Application number: 2025/93313	
What is the application for?:	Erection of two storey front extensions with balcony, two storey rear extension,
Address of the site or building:	68, Oxford Road, Dewsbury, WF13 4EH
Postcode:	WF13 4EH

Type of comment: An objection	
Do you wish your comments to be published on the website anonymously?	Yes
<p>I lodge a formal objection to the planning application on the following grounds</p> <p>1. SIZE, SCALE AND CHARACTER OF THE DEVELOPMENT</p> <p>The proposed new dwelling is wholly unsympathetic to the character and appearance of the immediately adjacent properties and the wider residential area. The houses on the north side of Oxford Road and the south side of Reservoir Street were constructed in the late 1950s as modest single storey bungalows set within generous plots, creating a valued sense of openness and privacy.</p> <p>This established character was already compromised by the approval of planning application 2007/62/92842/E2, granted on 13 September 2007, which allowed a full first floor extension at 68 Oxford Road, doubling the original floor area.</p> <p>The current proposal would create a dwelling four times larger than the floor area of th

Proposed South Elevation - 1:100

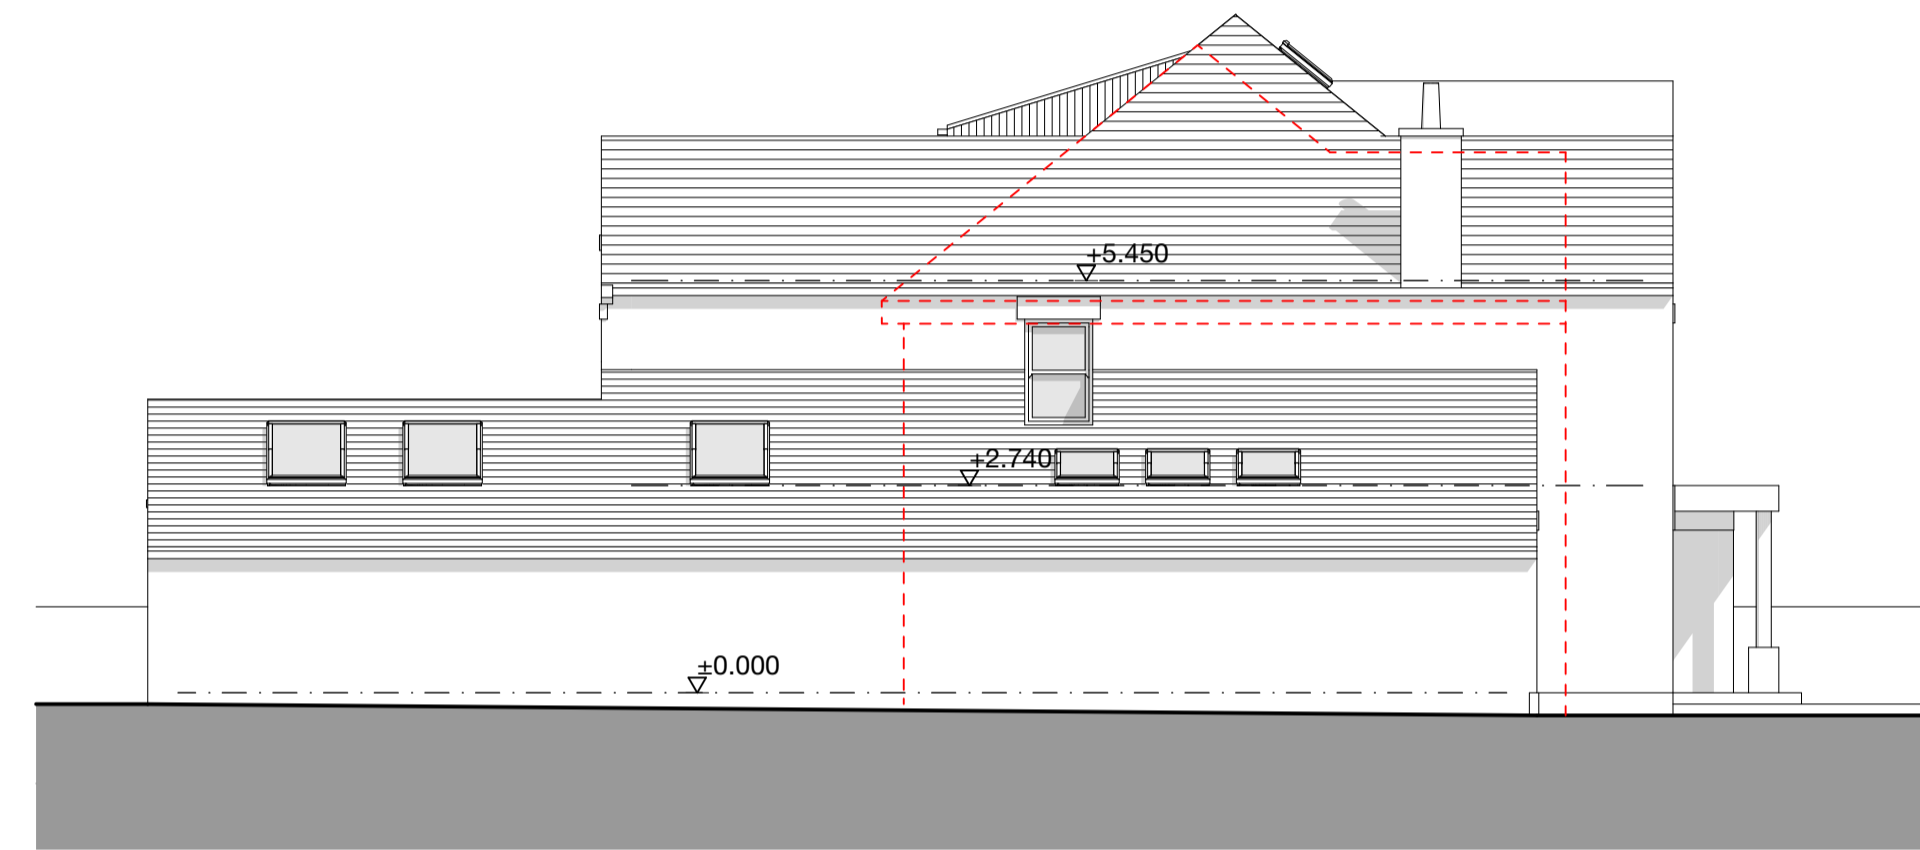
The unbalanced roof design and the inclusion of a roof terrace to the rear are unsympathetic to both the host dwelling and the surrounding area. The proposal fails to achieve a high standard of design and would appear visually discordant when viewed from neighbouring properties and gardens.

Proposed First Floor Plan - 1:100

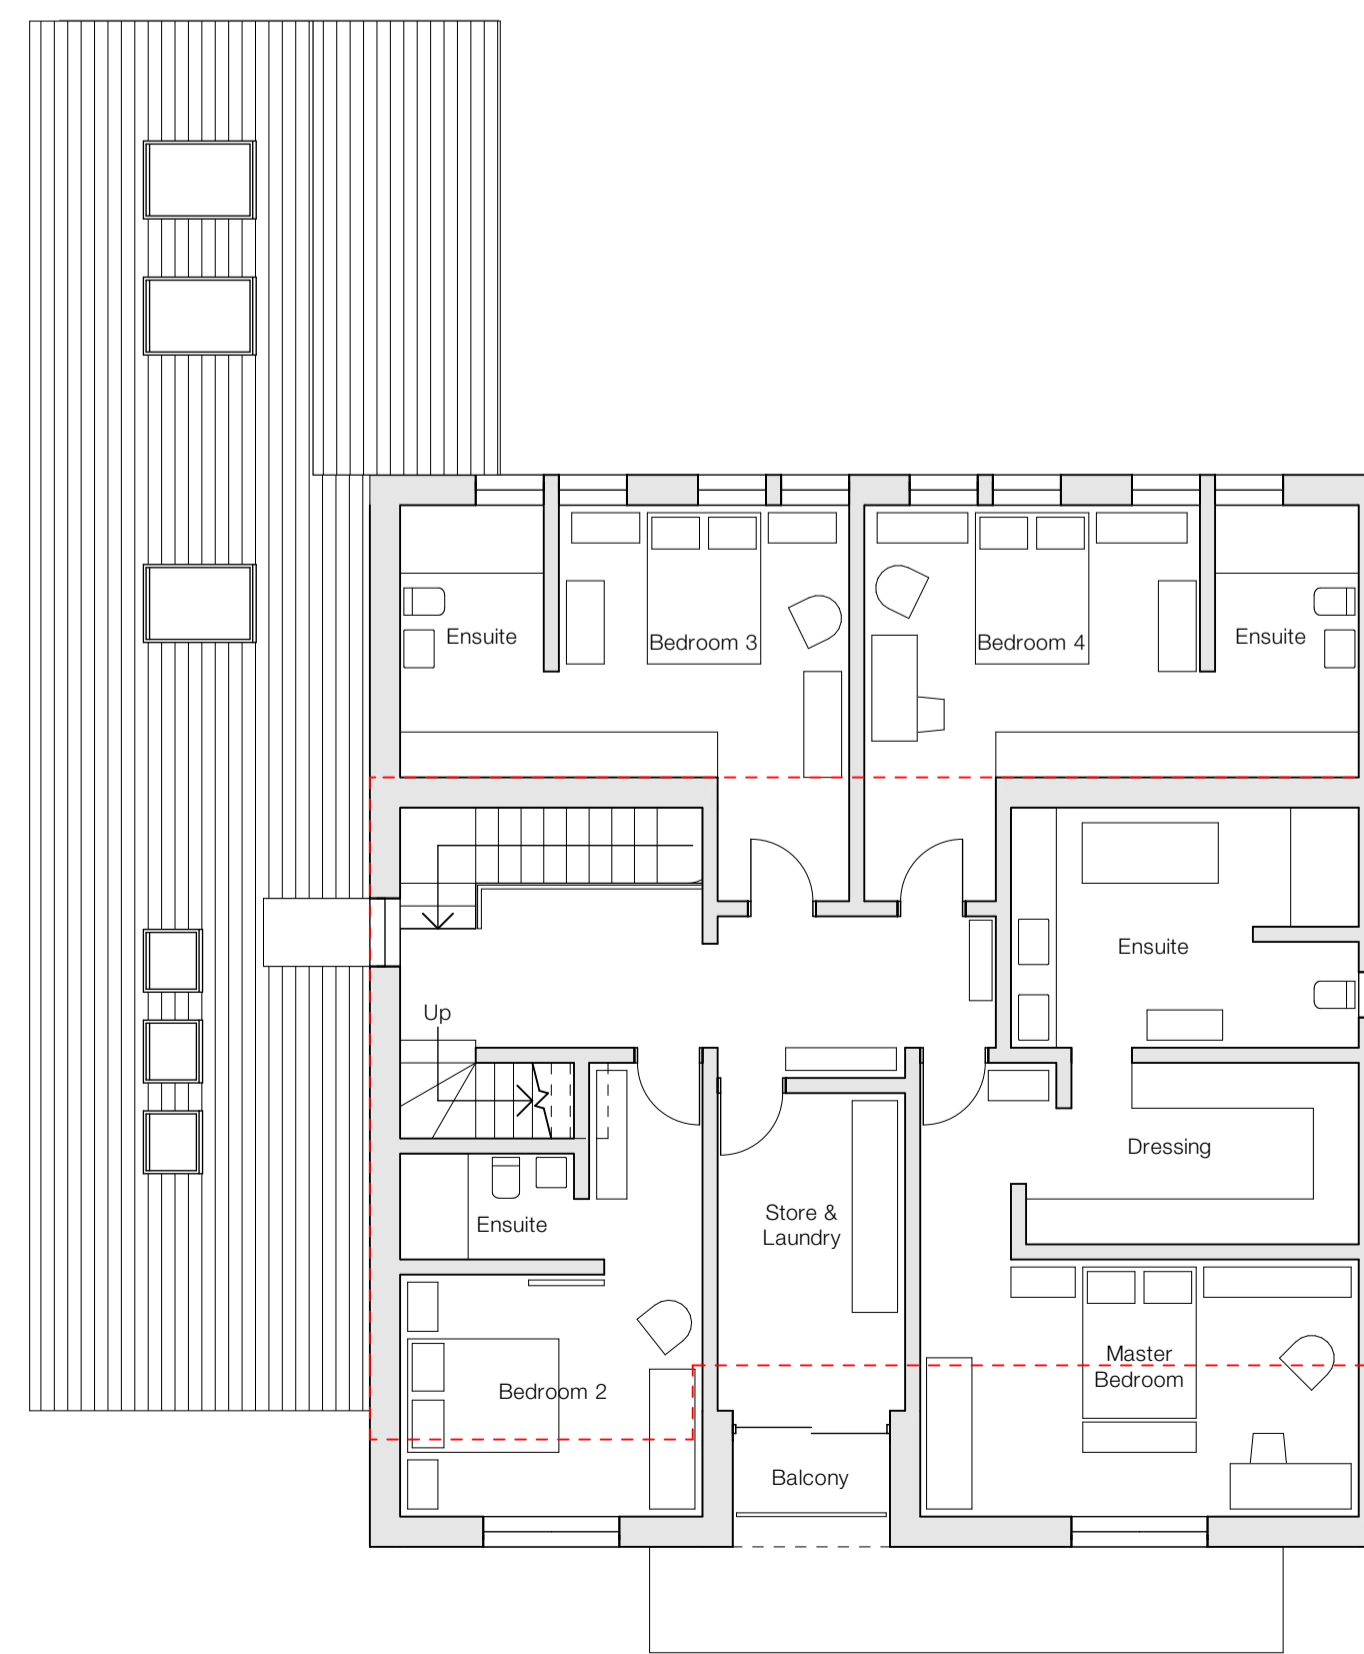
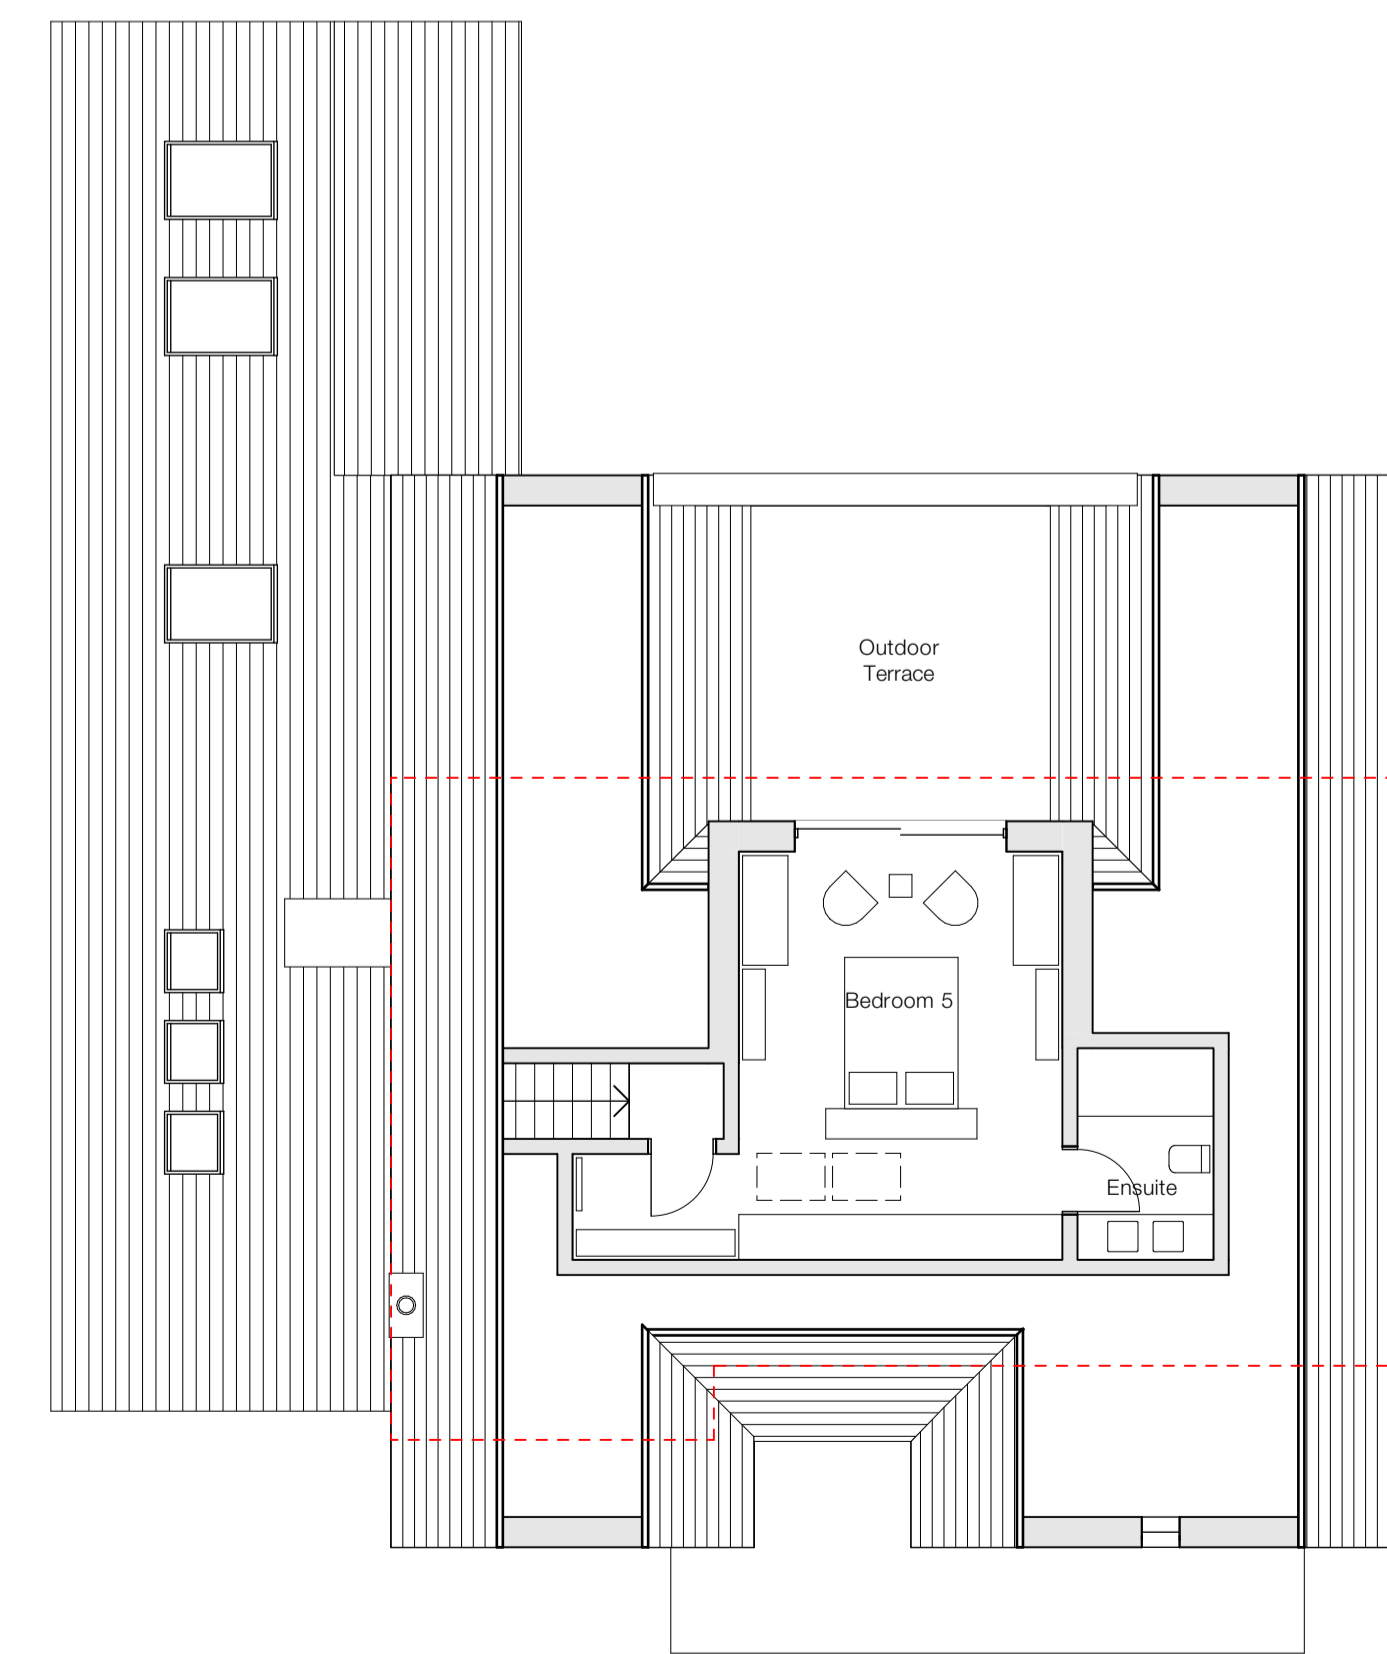
moving first floor windows 4 metres closer to the rear boundary and adding the full height second floor patio door and roof terrace, significantly increasing opportunities for overlooking.

There is no justification for an external amenity space at second floor level when the property benefits from a large rear garden. The proposed terrace serves no essential purpose and would cause substantial harm to neighbouring amenity.
